Tuesday, 17 September 2019

**WestConnex M4-M5 Link – Modification 2 The Crescent overpass**

I am writing to make an objection to the WestConnex M4-M5 Link – Modification 2 The Crescent overpass. Application number SSI 7485.

Figure 4-3 The Crescent, Johnston Street, Chapman Road intersection options

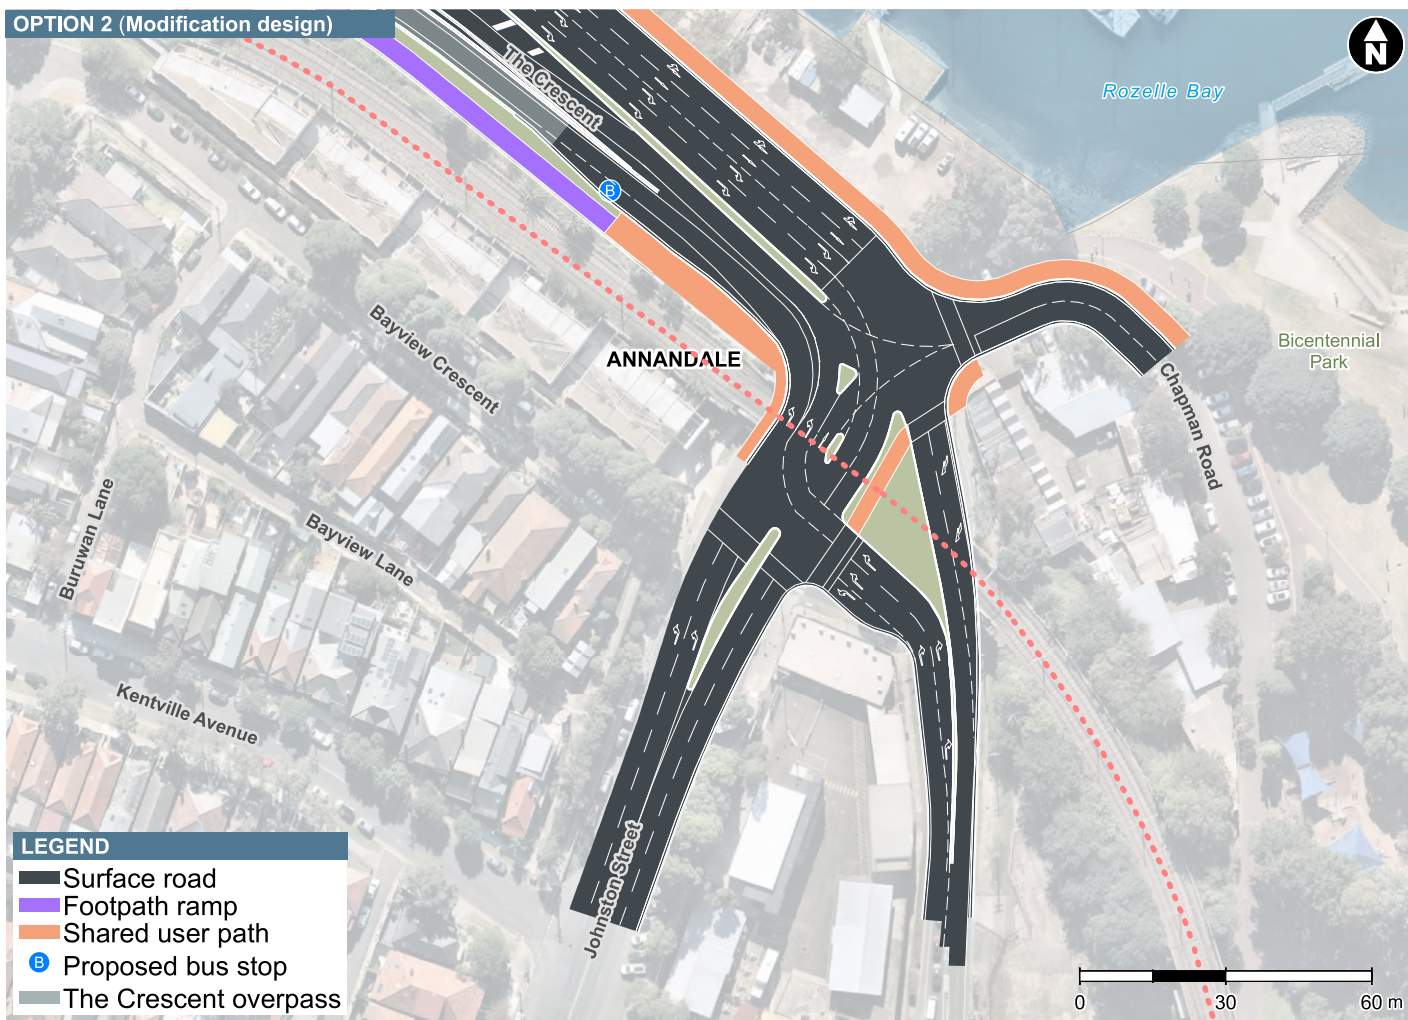
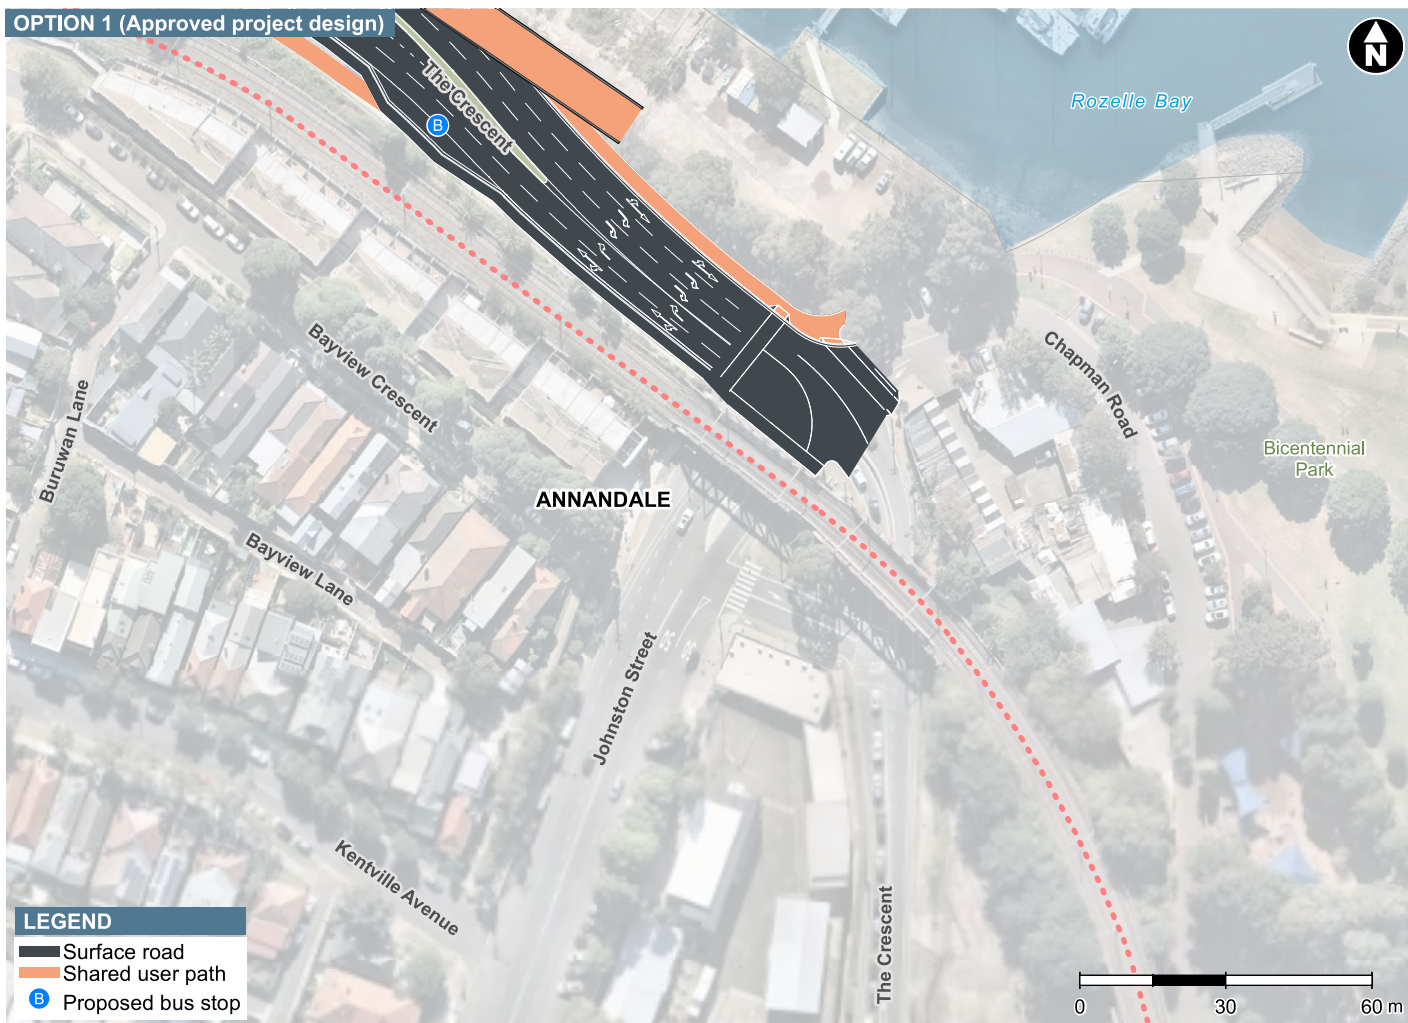
The Johnston Street crossing at The Crescent should be simplified to a single traffic light crossing in the current location on the Northern side of Johnston Street as currently exists. This would also ensure provision of easy at grade access from Railway Parade to the Glebe Foreshore with a direct connection to the simplified Johnston Street/The Crescent intersection.

This modification would remove the option to turn right out of Johnston Street into the Crescent which will increase traffic through local streets including Piper Street and Booth Street.

These changed conditions will mean increased noise and emissions for residents in Annandale. The intersection redesign should investigate the ability to easily turn right to access Glebe, The Tramsheds and other local destinations.

Figure 4-4 Elevation: Indicative view of The Crescent overpass

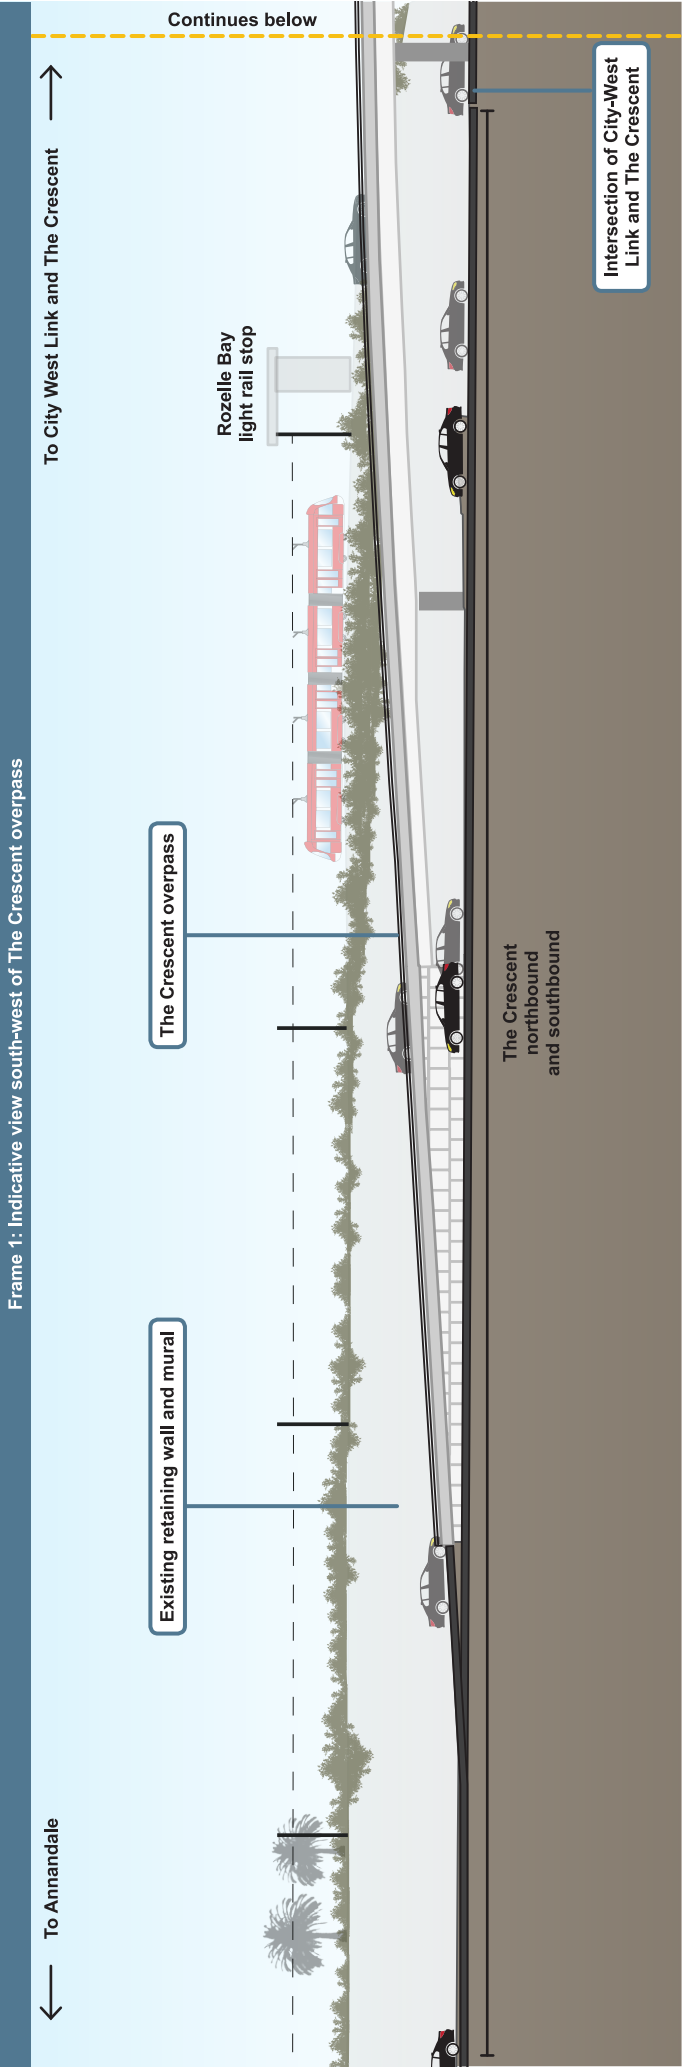
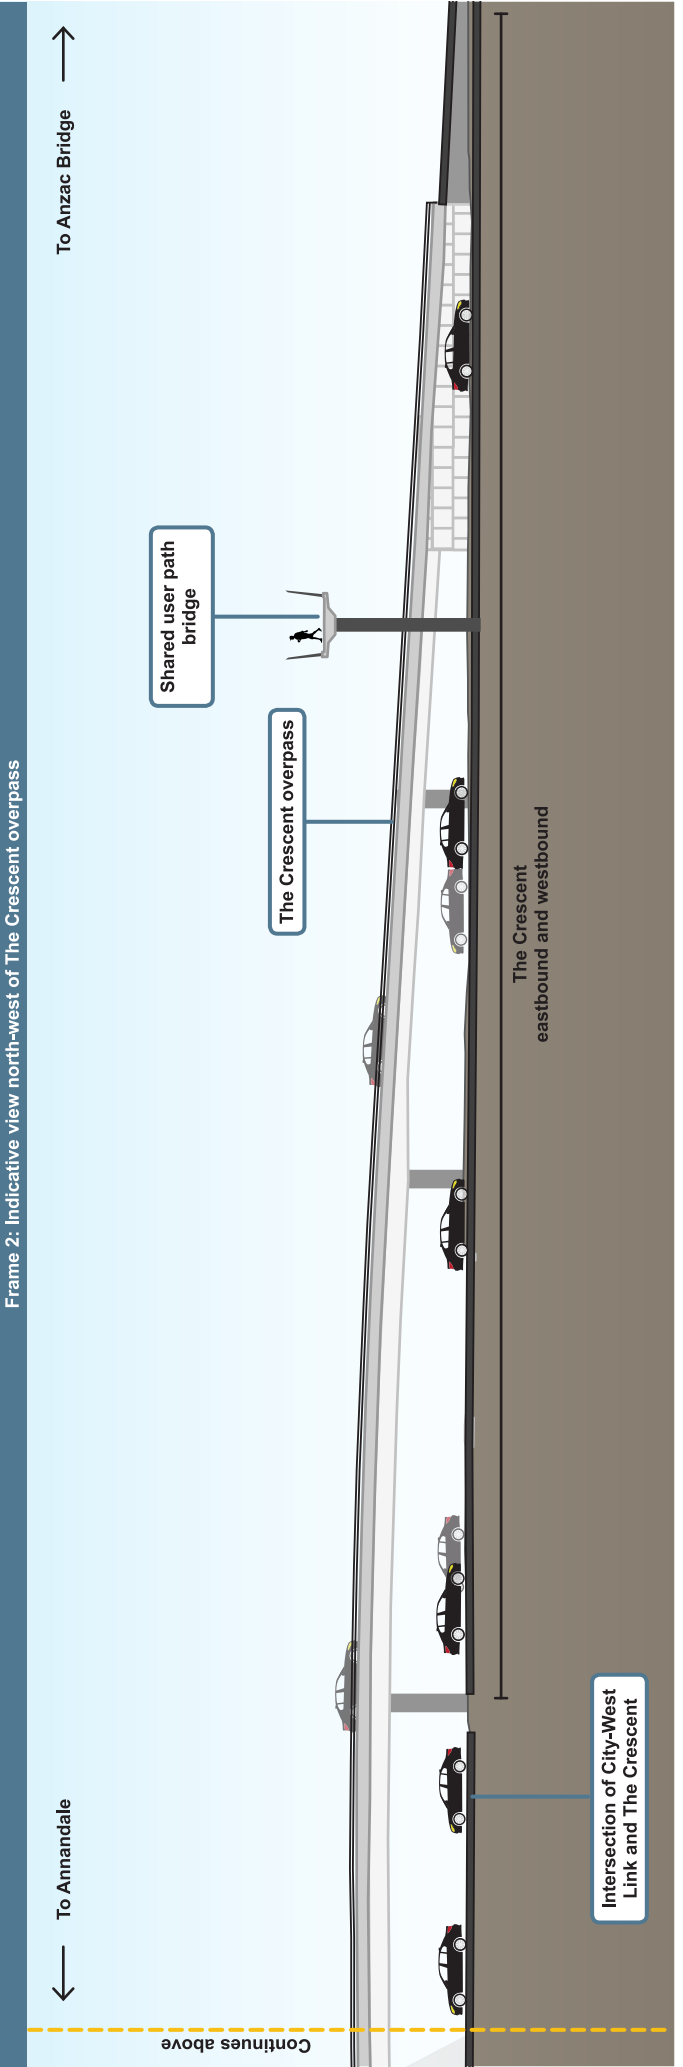
I strongly oppose the proposal to build an overpass at The Crescent in Annandale.

The plan for an overpass should be replaced by a short (less than 120m) tunnel under the City West Link with slot trench approaches.

The overpass solution is not our preferred outcome but if it is adopted, the bulk and scale must be reduced. One way to do this would be to reduce the allowed speed limit to reduce the curve of the proposal. Lowering the height of the overpass should also be considered.

Figure 4-6 Elevation: Indicative view of Rozelle Rail Yards Pedestrian and Cycling Green Link

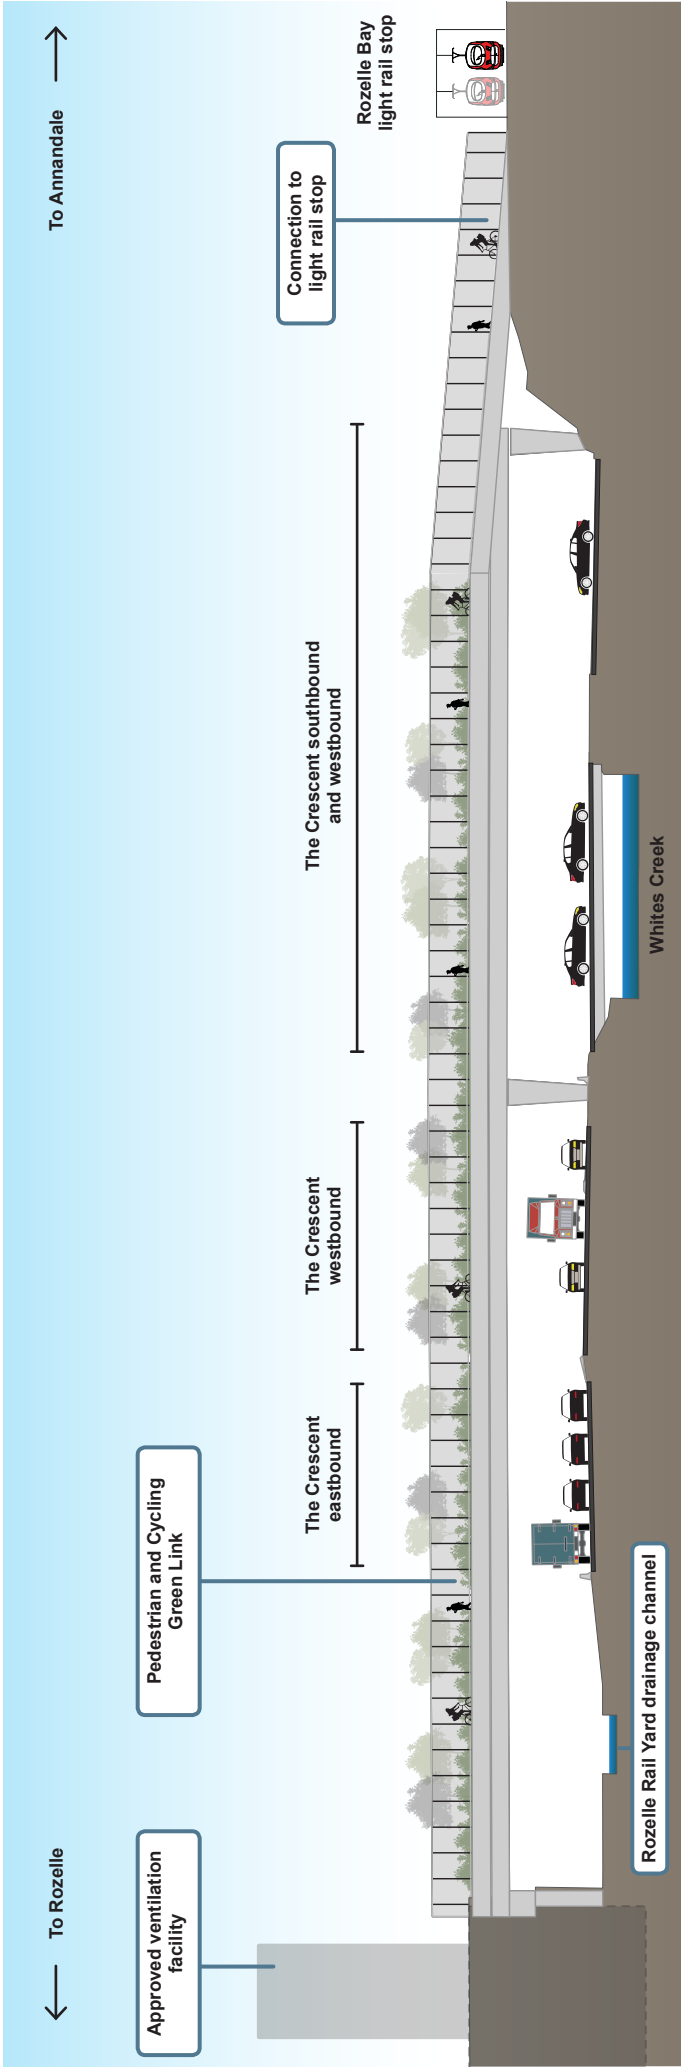
This modification alters one of the centrepieces of the original design: a pedestrian and cycling green link to connect the Glebe foreshore and Bicentennial Park to the new Rozelle parklands in the former Rozelle Goods Yard.

The green link was originally intended to provide a seamless grade separated connection for pedestrians between the Glebe foreshore parkland and the new Rozelle parklands. The relocation of the green link to the west due to the overpass now necessitates the crossing of the Crescent via a new, cumbersome pedestrian bridge.

Relocating the green link puts the needs of motorists ahead of pedestrians and cyclists. The original intent was safer and allowed for greater connections in and around the parklands and any modification should return to those outcomes.

There should also be a provision for the direct grade separated connection between The Glebe Foreshore and the new Rozelle parklands via the green bridge.
